RE: Mi Cancun

A plan review was received by this office concerning the construction of the above referenced facility. The plans and specifications submitted are approved with the following comments:

Jamie Turlington, REHS
Environmental Health Section
Harnett County Health Dept.

1 EQUIPMENT PLAN
SCALE: 1/4" = 1'-0"

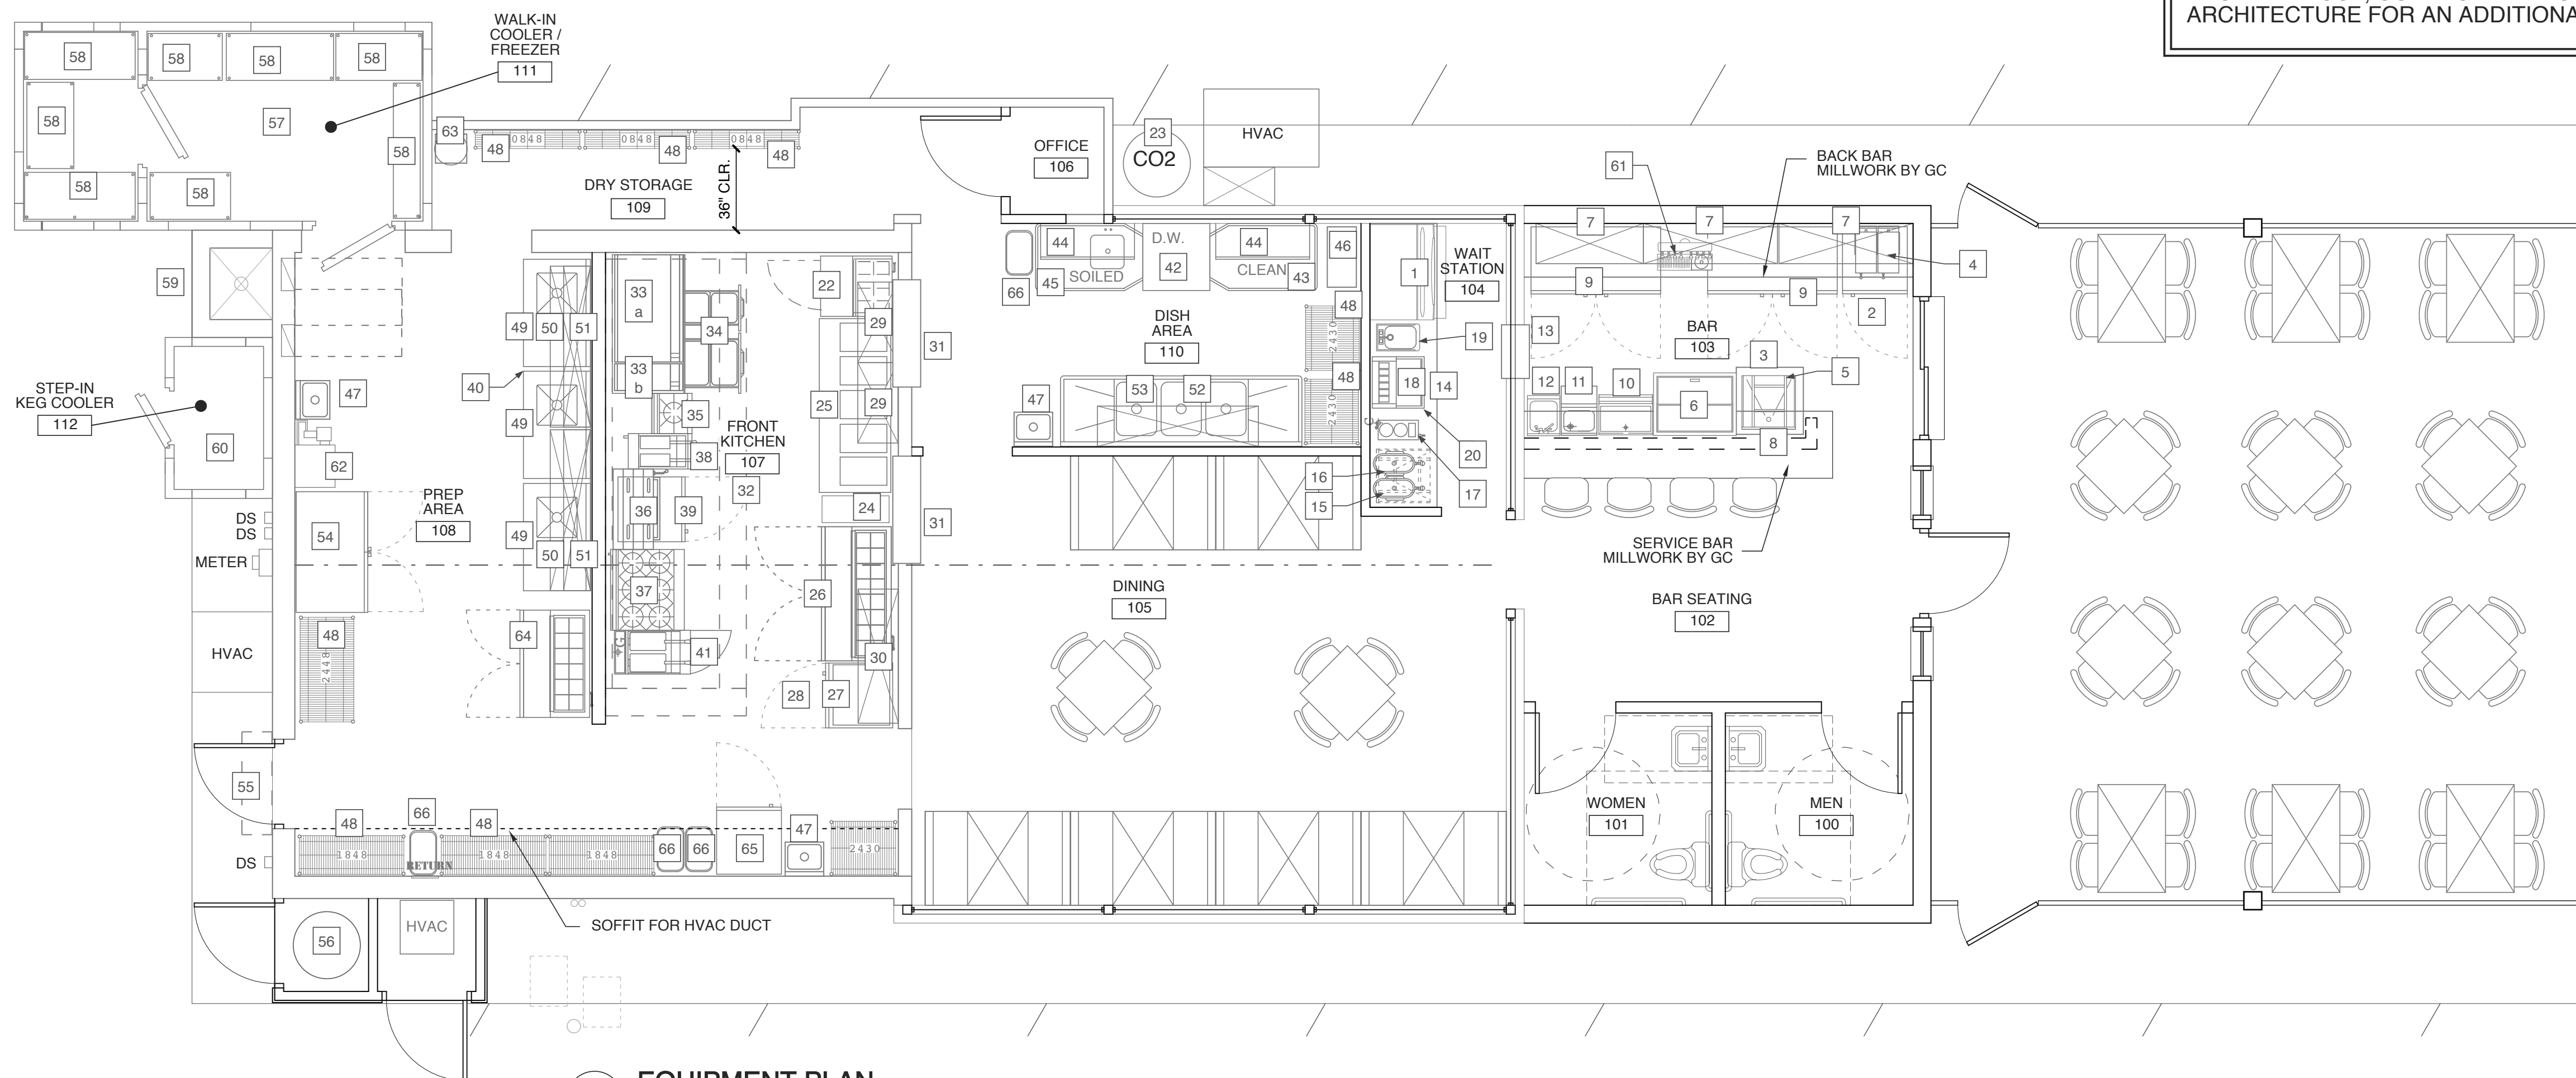
Changes to equipment specifications and plan are approved as per conversations with Ginger through email and by phone. Approved changes are moving the dirty staging rack closer to the dump sink, a solid top version of the dirty glassware staging rack, bar ice bin shall have a lid, wire shelf to replace speed rack, two door worktop refrigerator to replace condiment cooler in prep room and provide a self-closure on sliding window in bar.
